KITTITAS COUNTY

MEMORANDUM

TO: All Staff
FROM: Public Works Plan Review Team
DATE: July 30, 2025
SUBJECT: SP-25-00009 Brown Road

BROWN ROAD SHORT PLAT
 PART OF SECTION 4, T. 17 N., R. 18 E., W.M.
 KITTITAS COUNTY, WASHINGTON

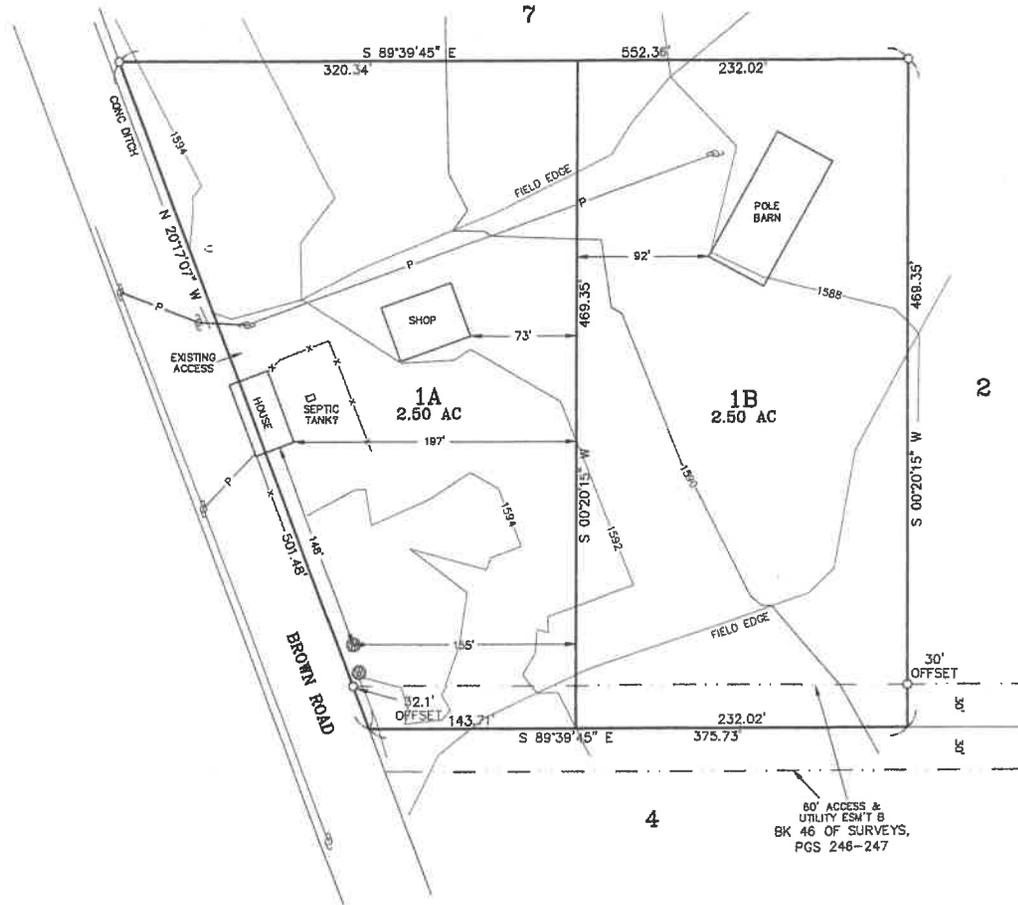
<p>SURVEY</p>	<p>1. Application does not meet WAC 332-130-145 Topographic elements on map. 2. show encroachment distances of existing building(s) into Brown Road Right of way. 3. 2024 Aerial photography shows 5 additional buildings not shown on the application. These should be shown or a statement from the applicant stating that they have been removed.</p> <p>FOR FINAL (not required for Prelim Approval)</p> <p>4. Include Ownership, surfacing and R/W width for Brown Road. 5. At a minimum, the new division line between parcels shall be staked in the field, and corners shown on the face of the map. 6. Adjacent lots 2, 4 and 7 shall include reference to recorded survey. 7. The 60' access easement shall include reference to recording number of the creation documents, as the survey only notes that is to be created by separate document. 8. Given the simplistic nature of the SP, Lot Closures are not required at final. (JT)</p>
